Your Ref
EG/70/18/HH
Our Ref
PLAN-0025165
Date
13/11/2018

Proposal: Two storey rear & single storey side extensions.
Site: 23 Elm Grove, South Barnham, PO22 0EJ.
EG/70/18/HH

03

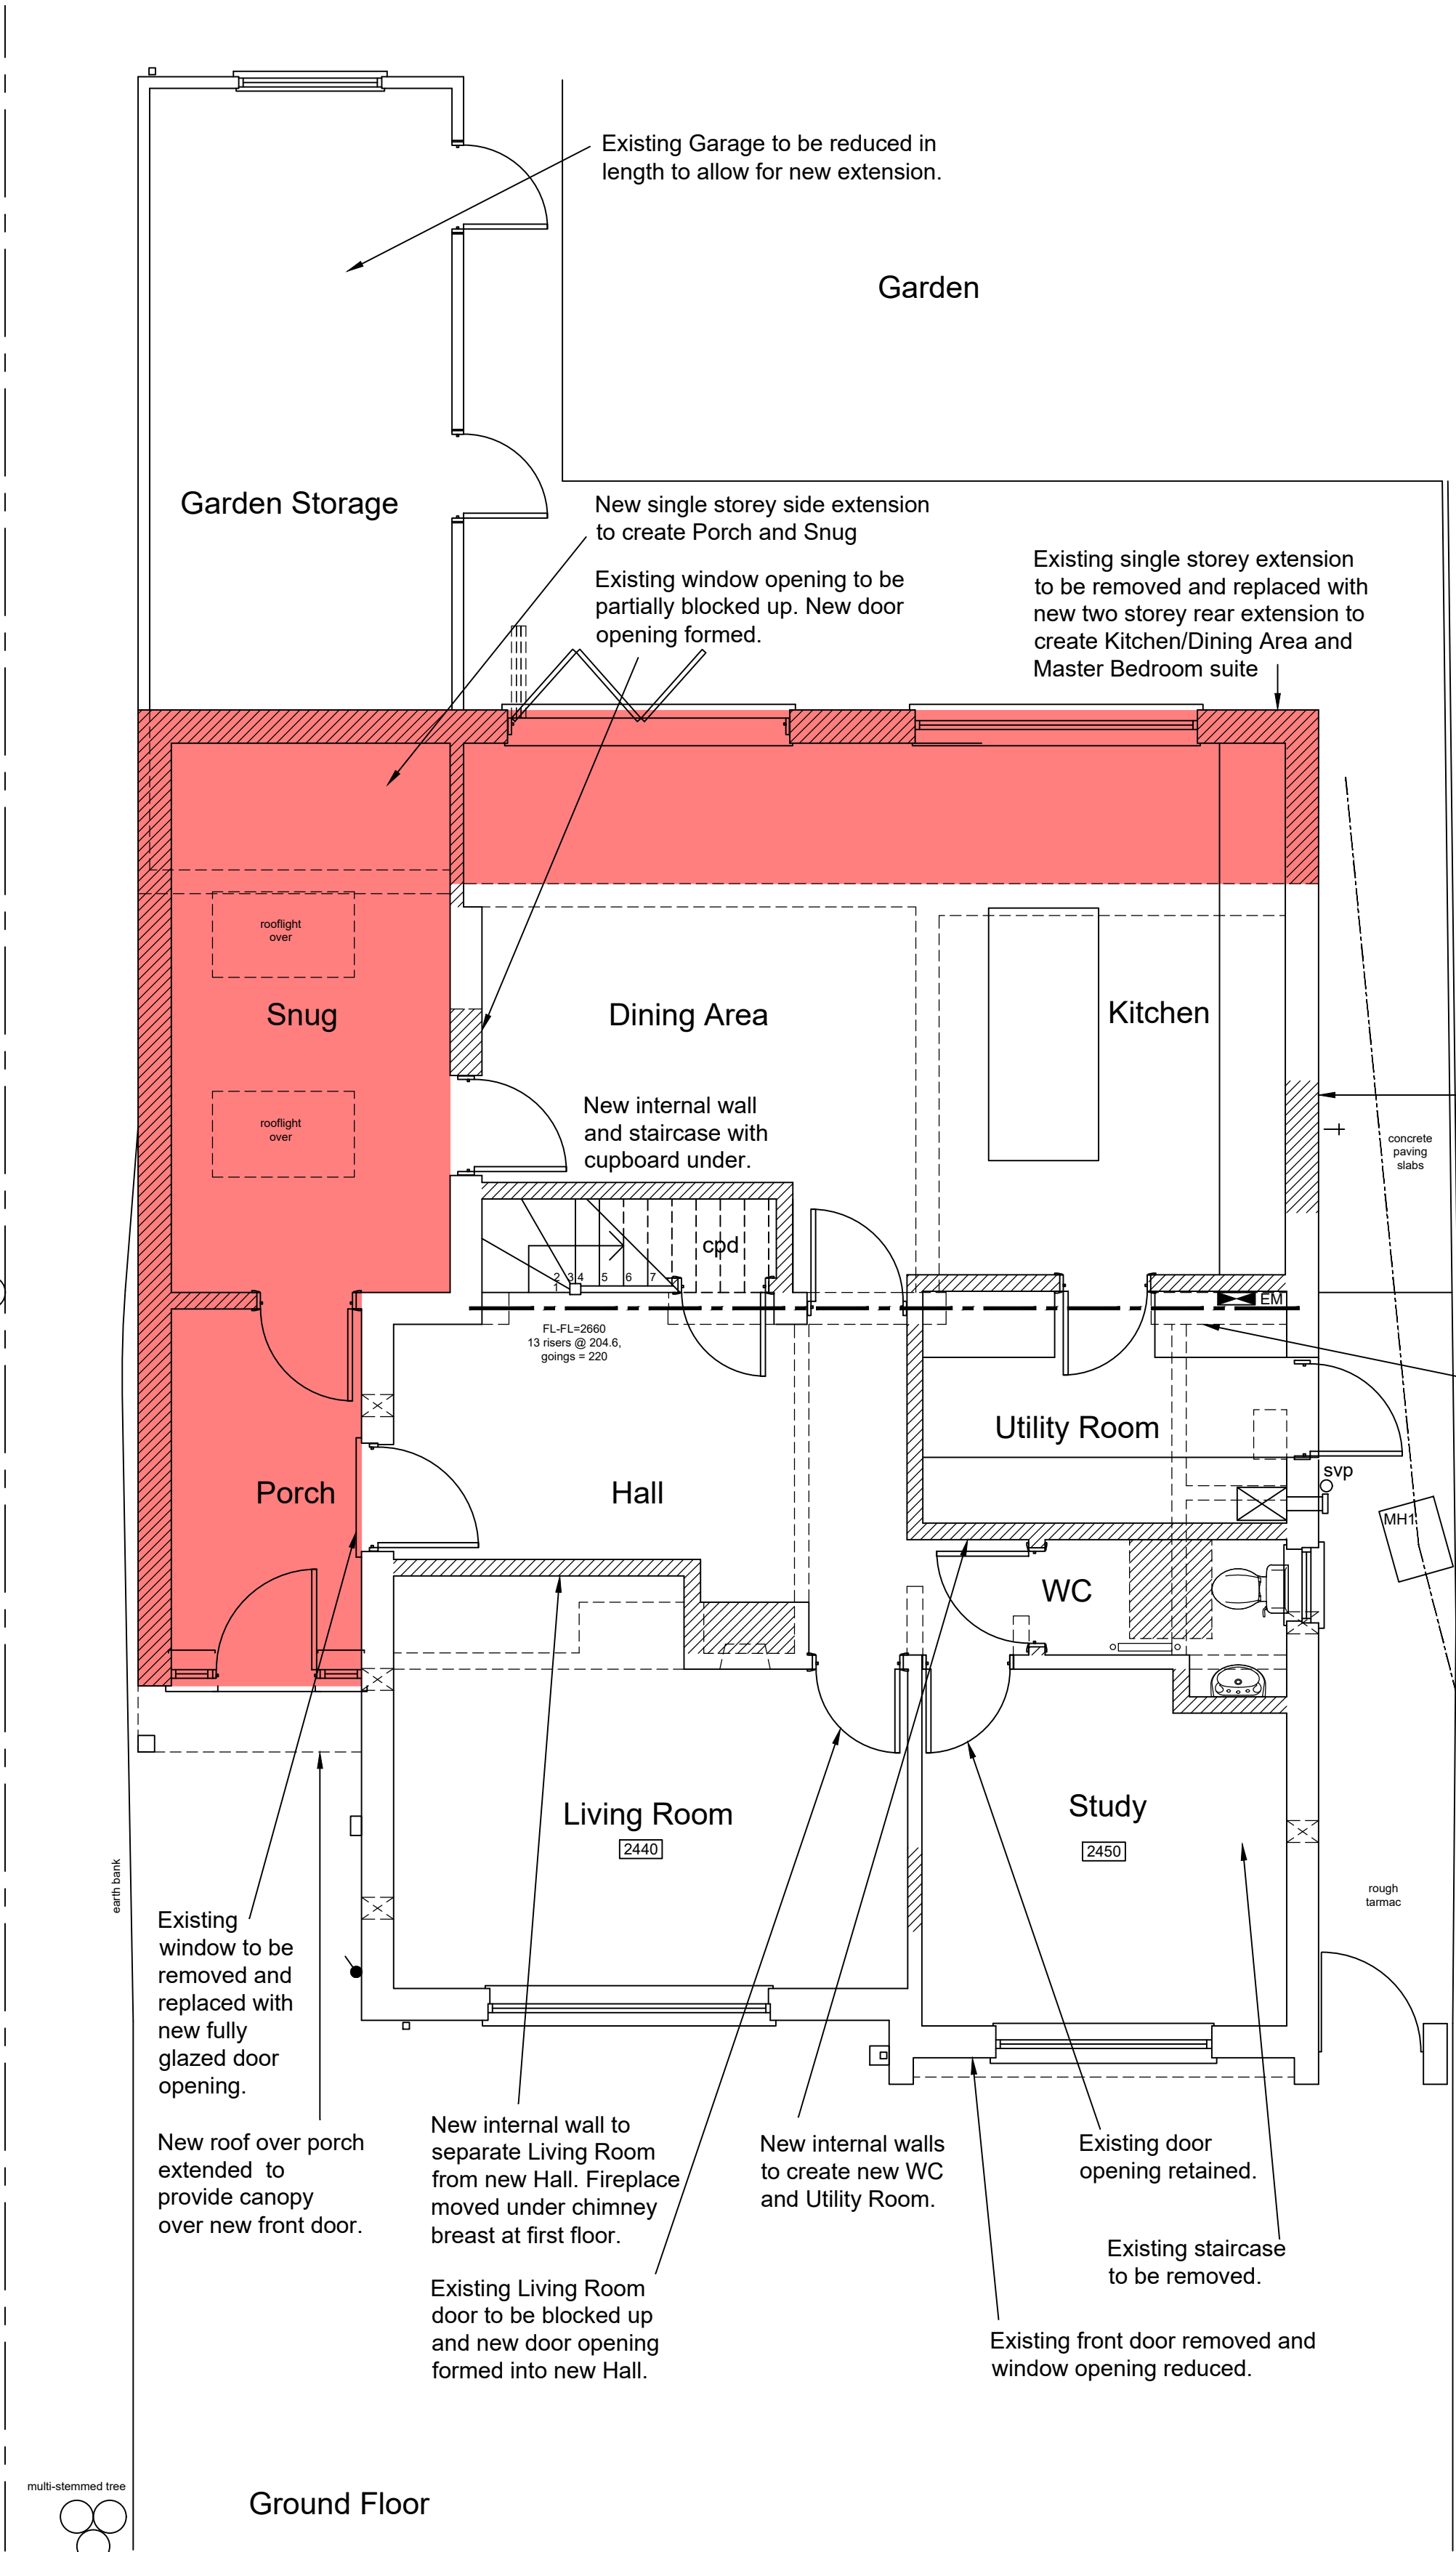
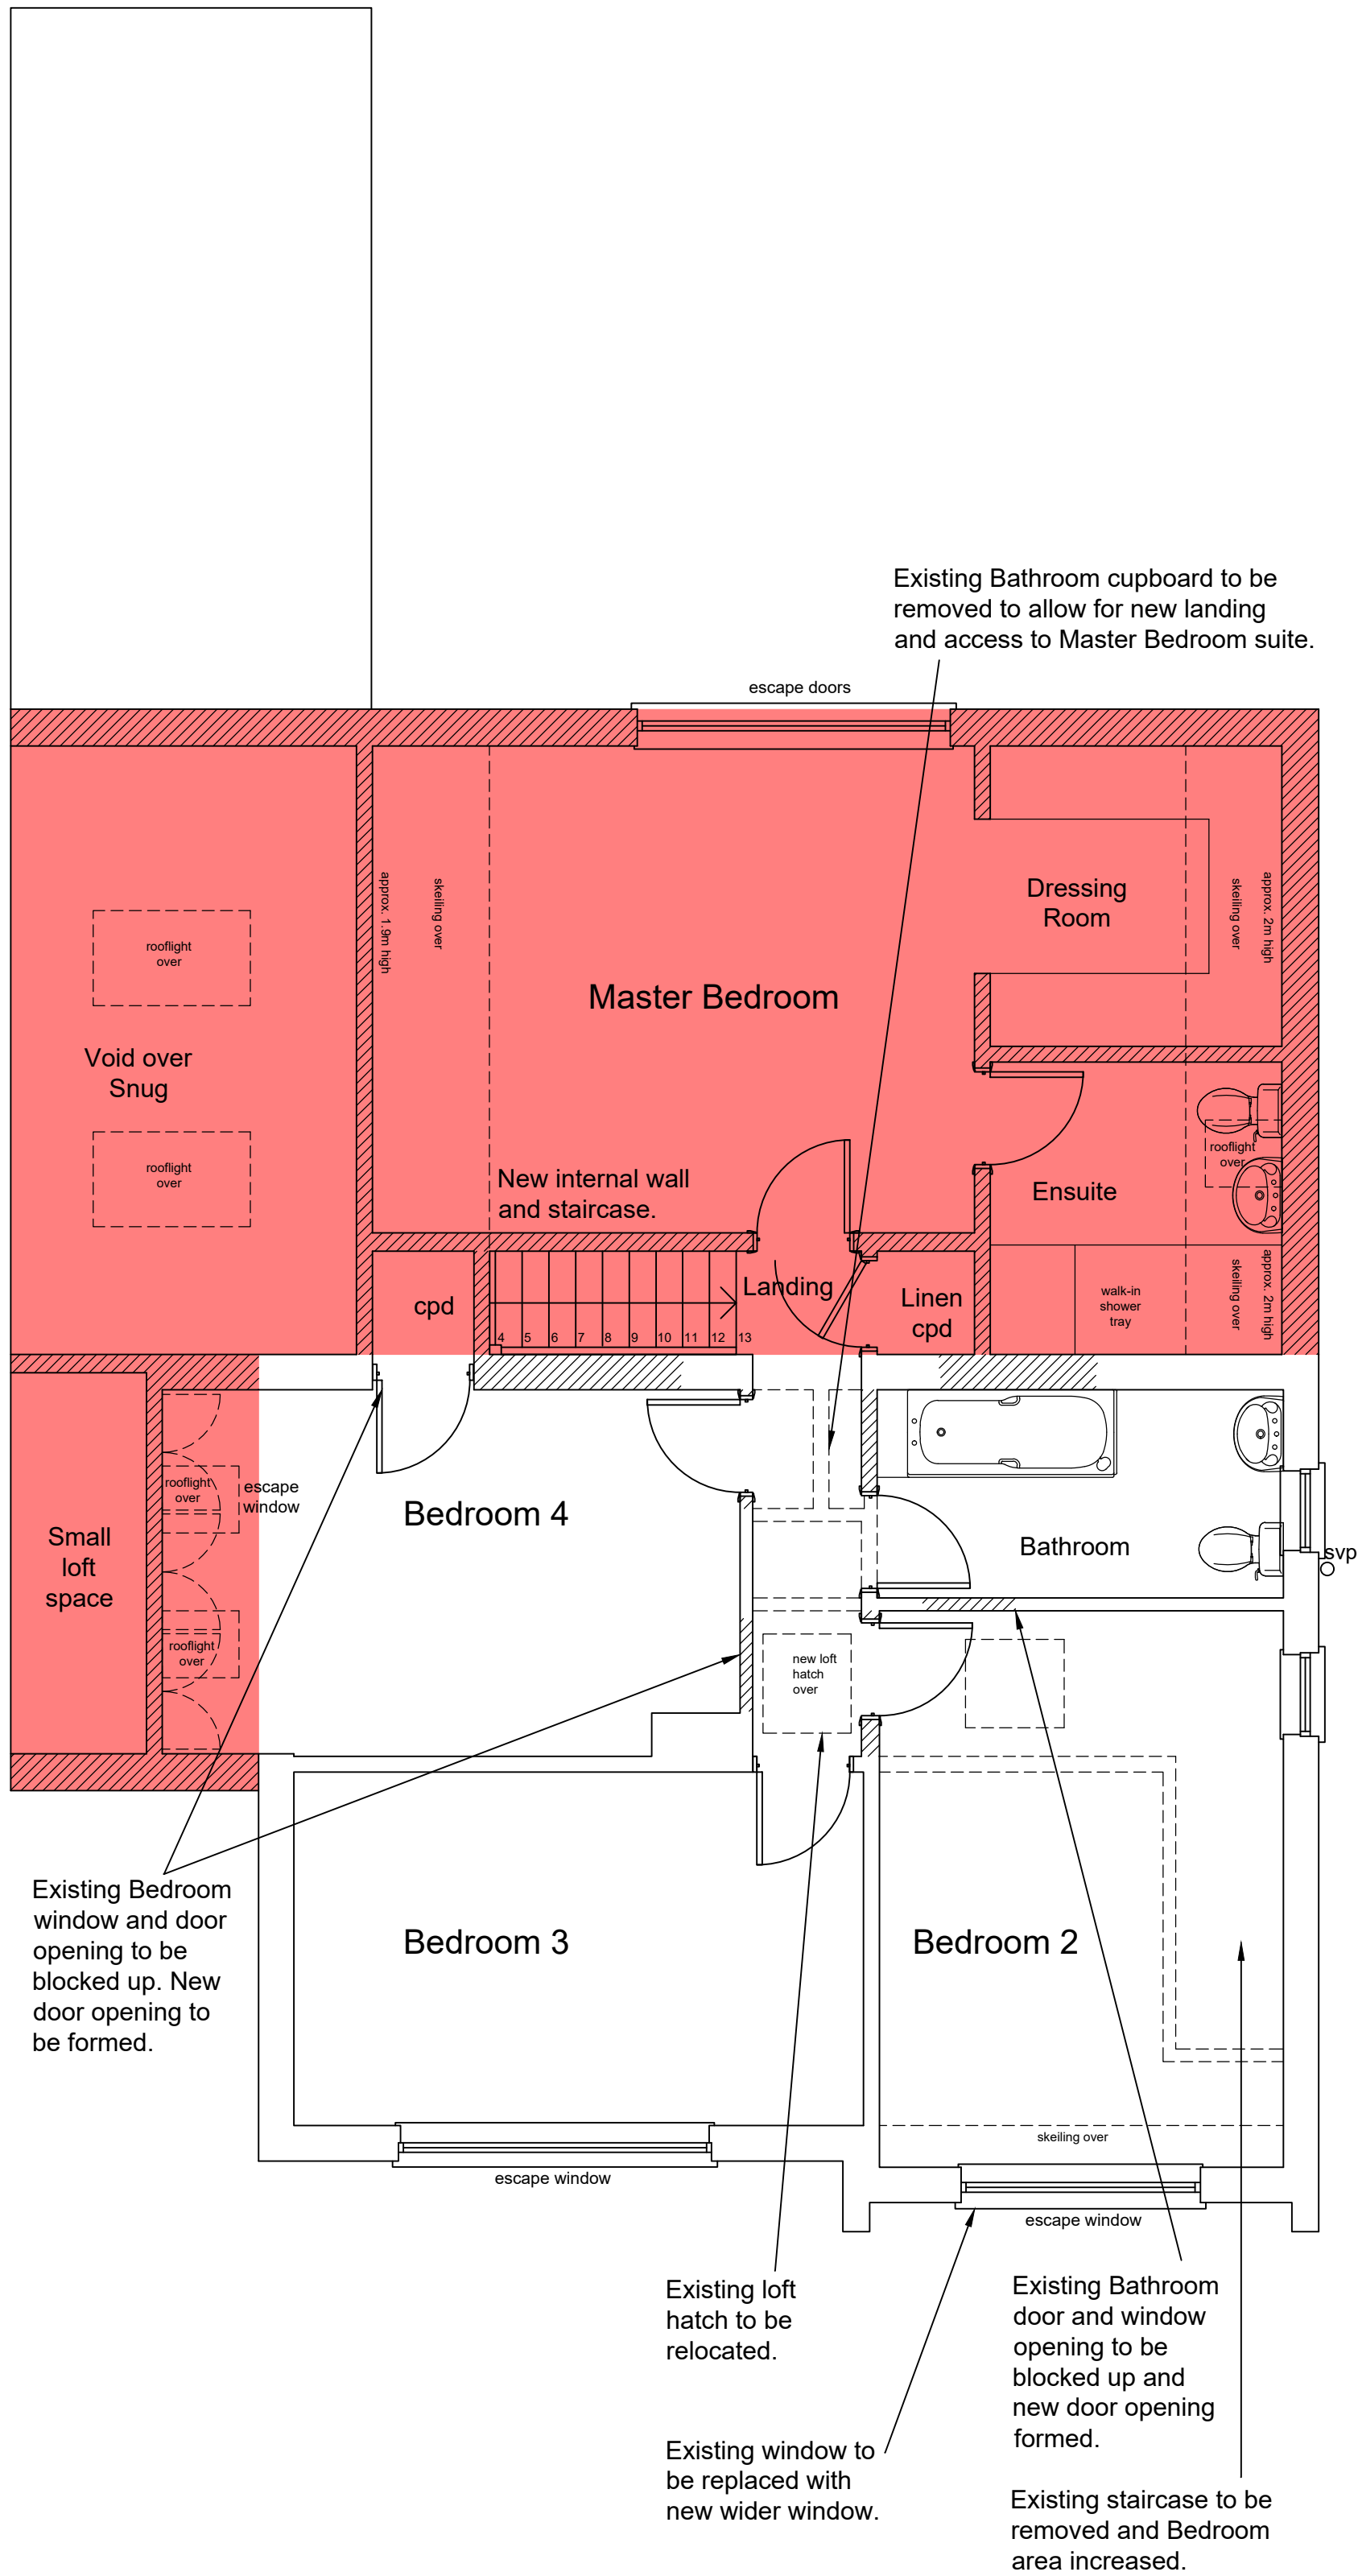
The submitted plan, drawing number 03 Rev C, shows a public sewer within the site not shown on records. It appears that the developer is intending to build close to a public sewer. Building over a "public sewer" is not normally permitted by Southern Water. An investigation of the sewer is required to ascertain its condition, the number of properties served, and potential means of access, before any decision can be made as to whether it would be acceptable for the proposed development to be built close to the sewer. Part H of the Building Regulations dictates that the matter is determined by the sewerage undertaker – in this case Southern Water.

In order to protect drainage apparatus, Southern Water requests that if consent is granted, a condition is attached to the planning permission For example: "The developer must agree with Southern Water, prior to commencement of the development, the measures to be undertaken to protect the public sewer."
